# CITY OF ALBUQUERQUE

PLANNING DEPARTMENT – Development Review Services

**RE: Marie Hughes Elementary School – 2701 Mojave Street, NW  
Grading and Drainage Plan for Building Permit  
Engineer's Stamp Date 7-31-2015 (D11D007)**

## GRADING PLAN

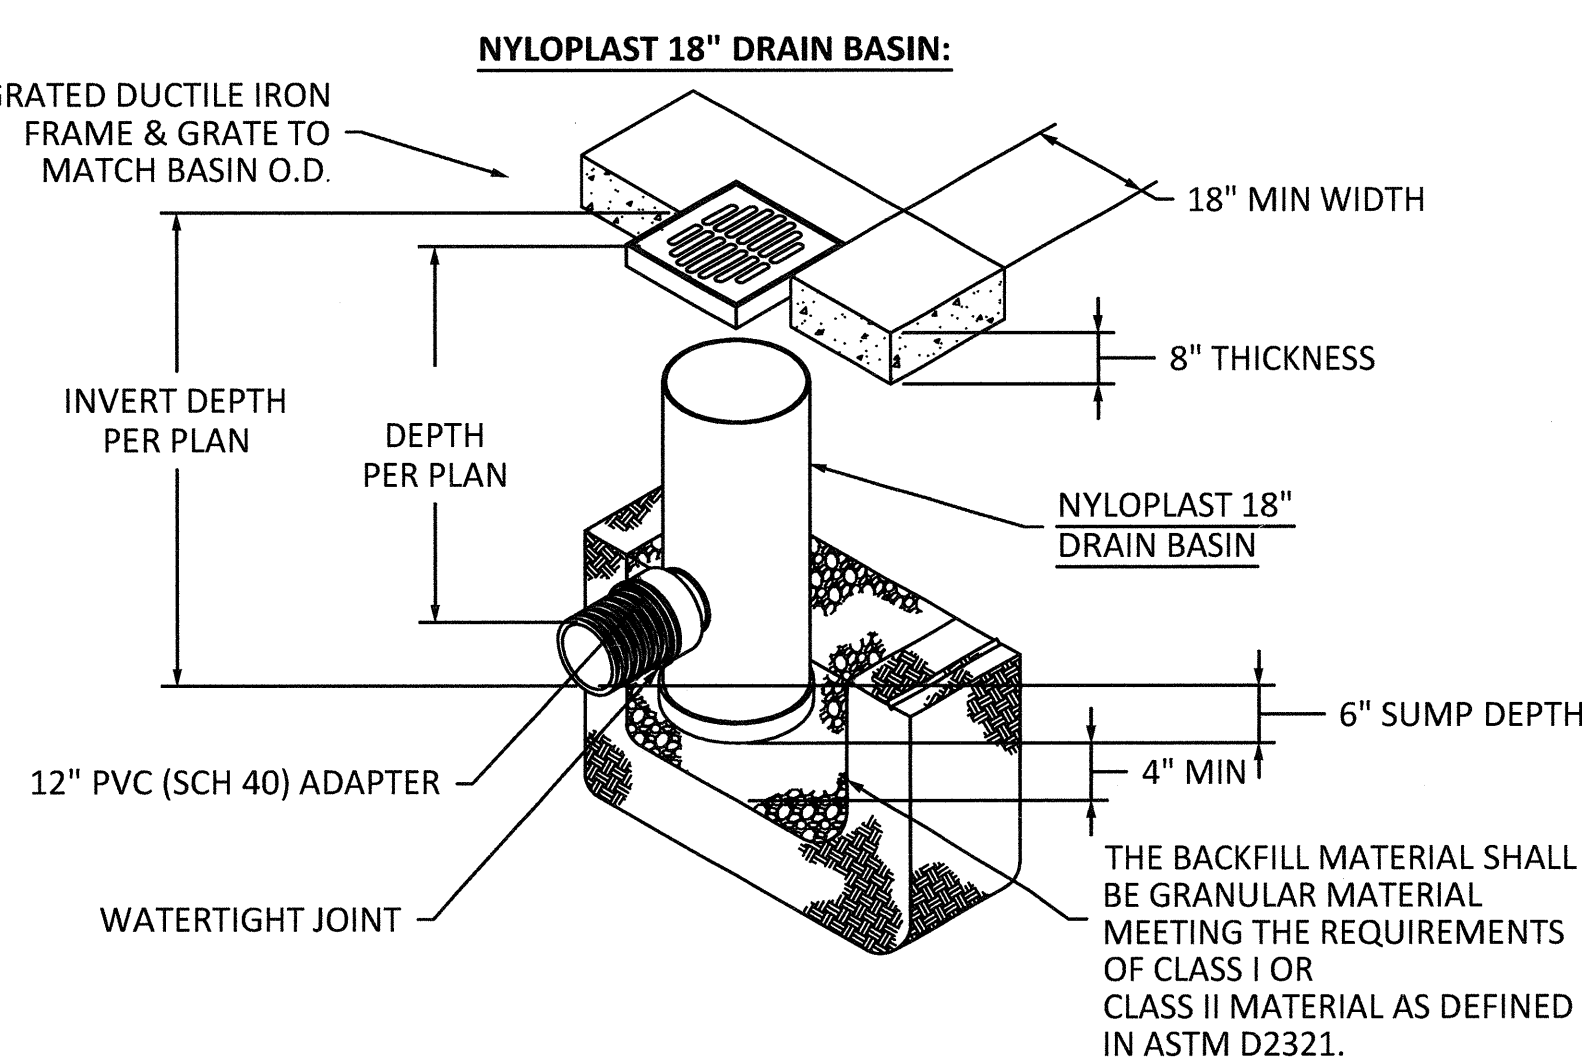
1. In the street capacity calculations:
  - a. Provide a basin map showing the upstream drainage area contributing to the street flows.
  - b. In the Manning's equation, show how input values are determined.

- c. Show that the inlets can collect flows from the street and this development without flooding .
  - d. Are inlets in a sump? Contour information is cut off.

2. The older plan by JMA in 1995 states that the outfall for this site was the Mariposa Diversion Channel, and there is already a penetration into the channel. Discharging directly into the Channel is the preferable option and should be re-evaluated. I believe there is already a penetration into the channel.

3. Analysis Points:
  - a. Provide calculations for inlet and culvert capacities shown on table in "Notes"
  - b. The 4 Analysis Points add to 6.8cfs, but the total is 32.7 cfs. Provide an onsite basin map showing the contributing flows from each basin.

- c. Show amount of flow at all discharge points – into streets, ponds , inlets, etc.
  - d. Basin Map should show how much flow is going in private storm drain system. Provide capacity calculations for the private Storm Drain.

4. How much flow is discharging into the most easterly pond (connected to inlet)? How much flow is discharging out of pond? Since it is functioning as detention pond, what is the Max WSEL? Provide calculations.
